OXFORDSHIRE COUNTY COUNCIL'S RESPONSE TO CONSULTATION ON THE FOLLOWING DEVELOPMENT PROPOSAL

Application no: 21/01454/F

Proposal: Proposed Bicester Health and Wellbeing Hub

Lead Local Flood Authority

Appendix F – Drainage Strategy Drawing

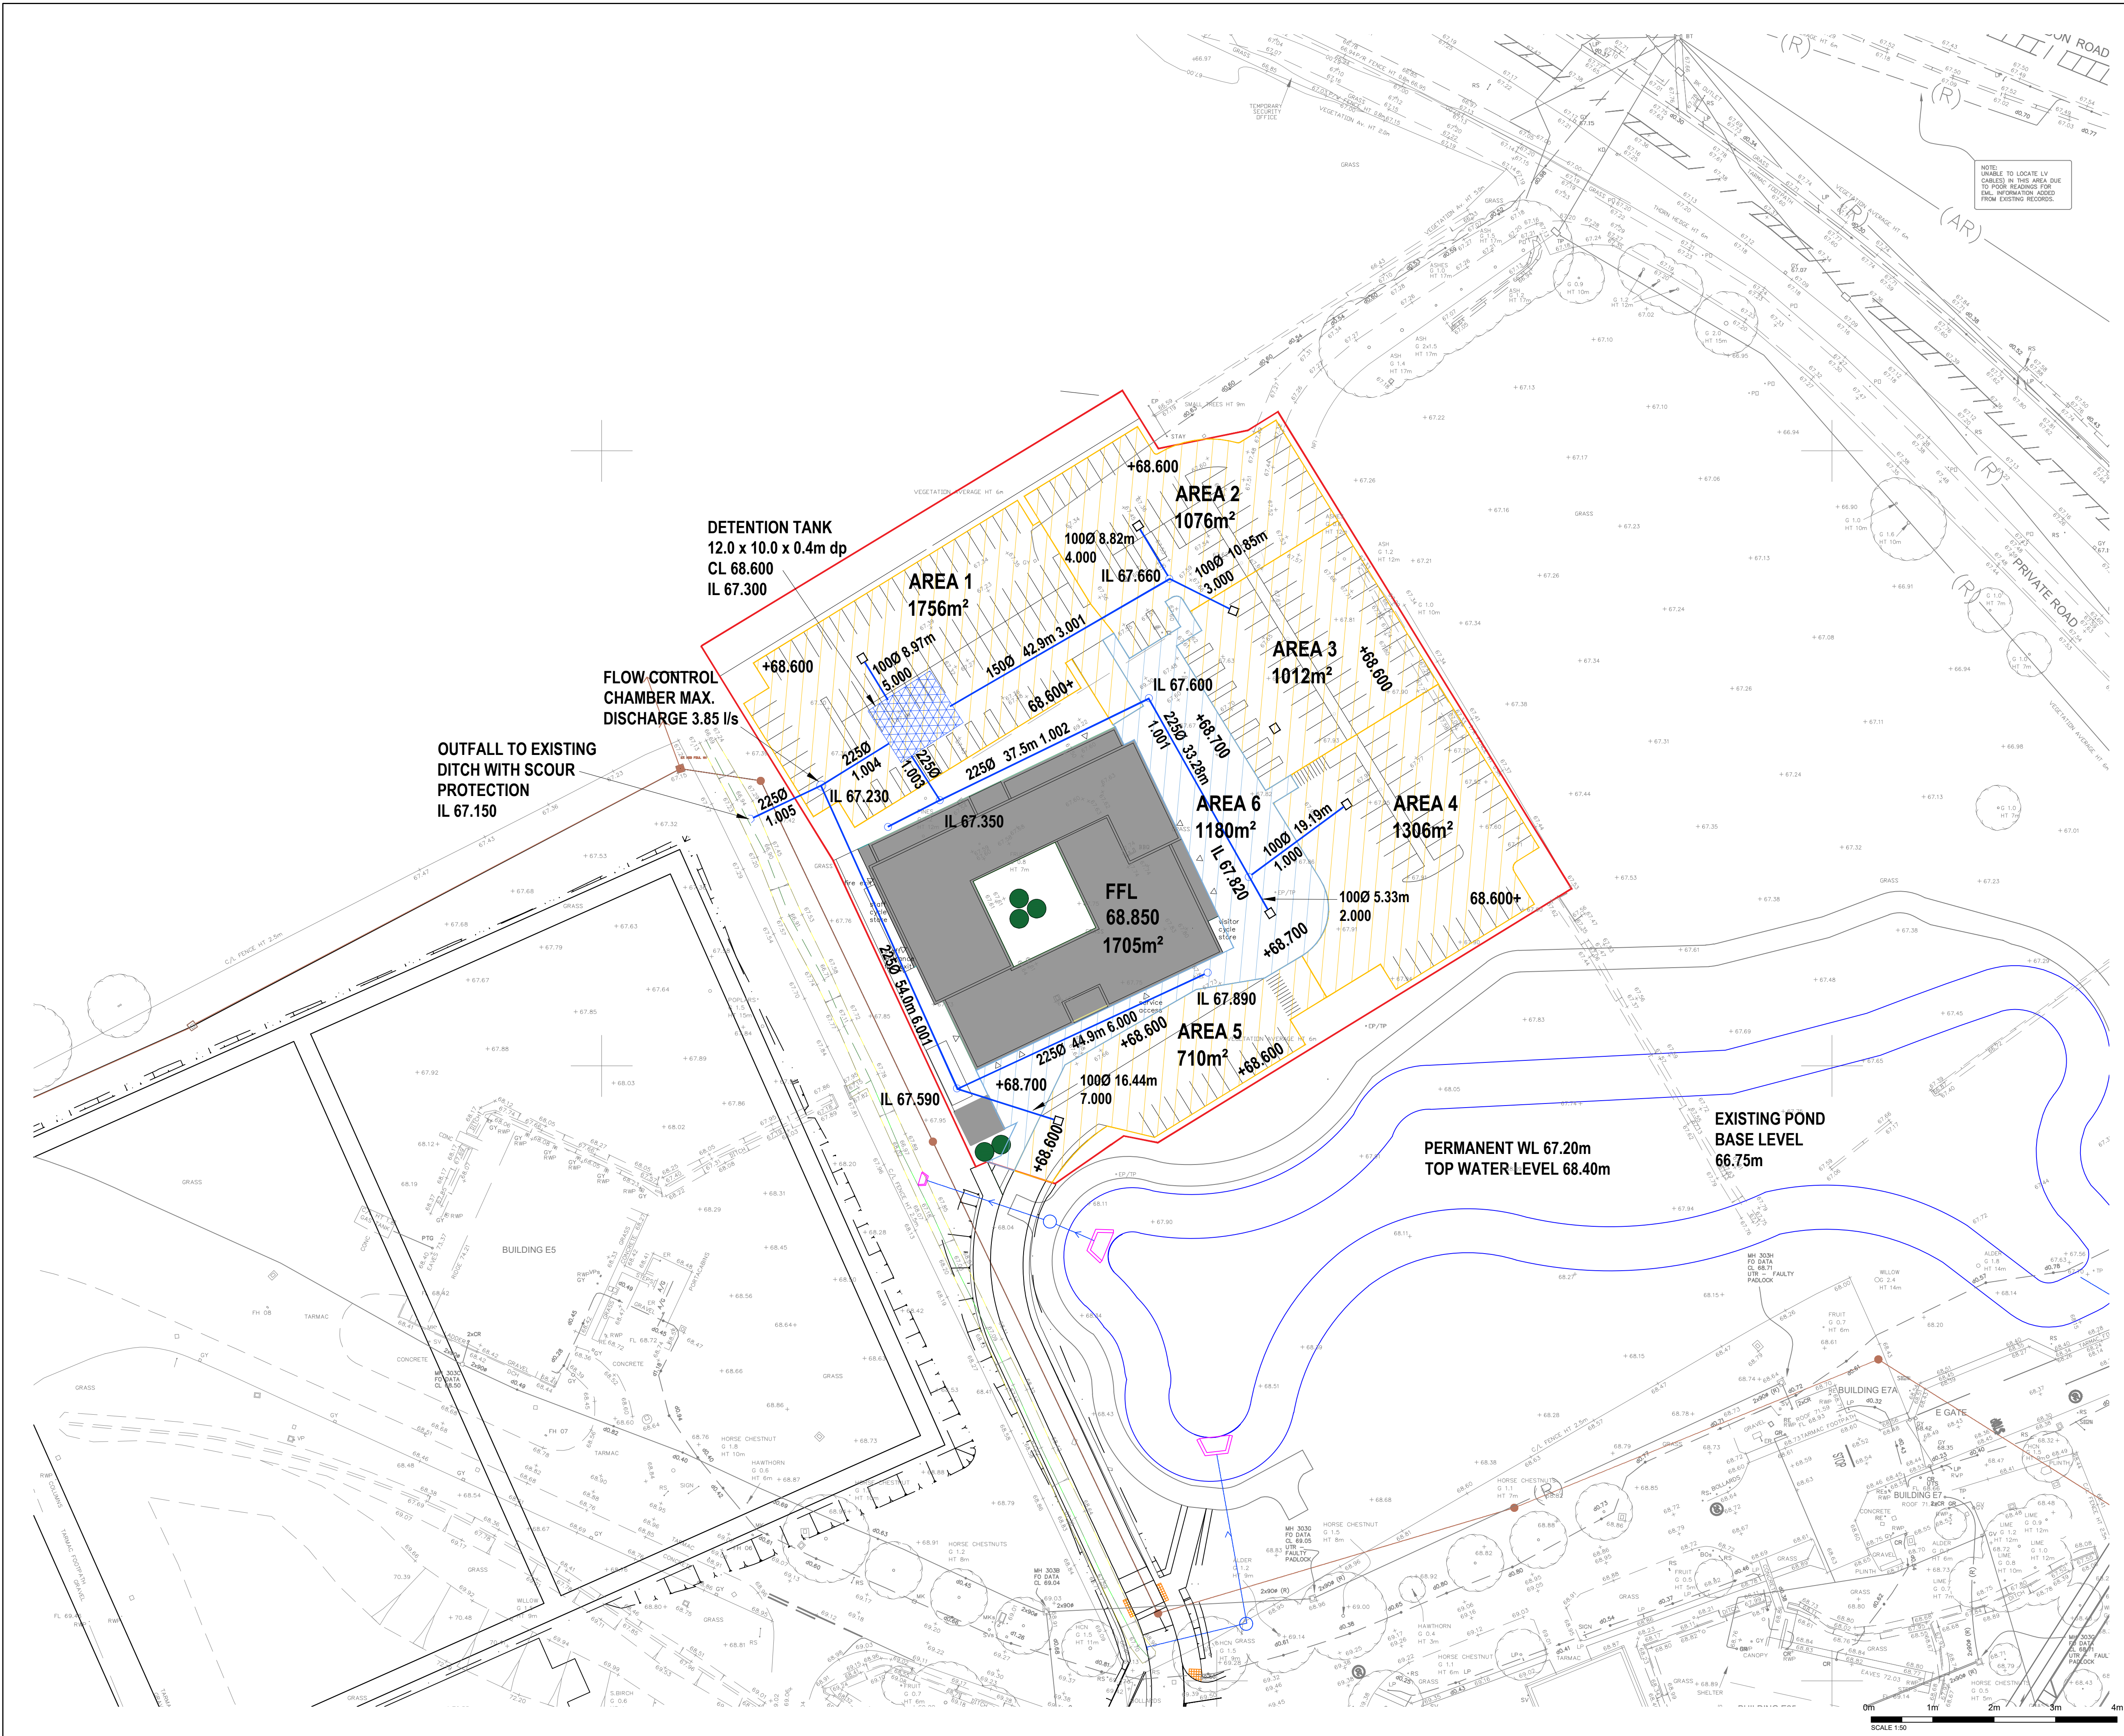
The hydro-brake is designed to discharge at maximum 3.85 l/s however the 1:1 year greenfield run off rate for the site is calculated to be 3.74l/s. Please update the Microdrainage results and drainage strategy drawing to suit the correct greenfield run off rate.
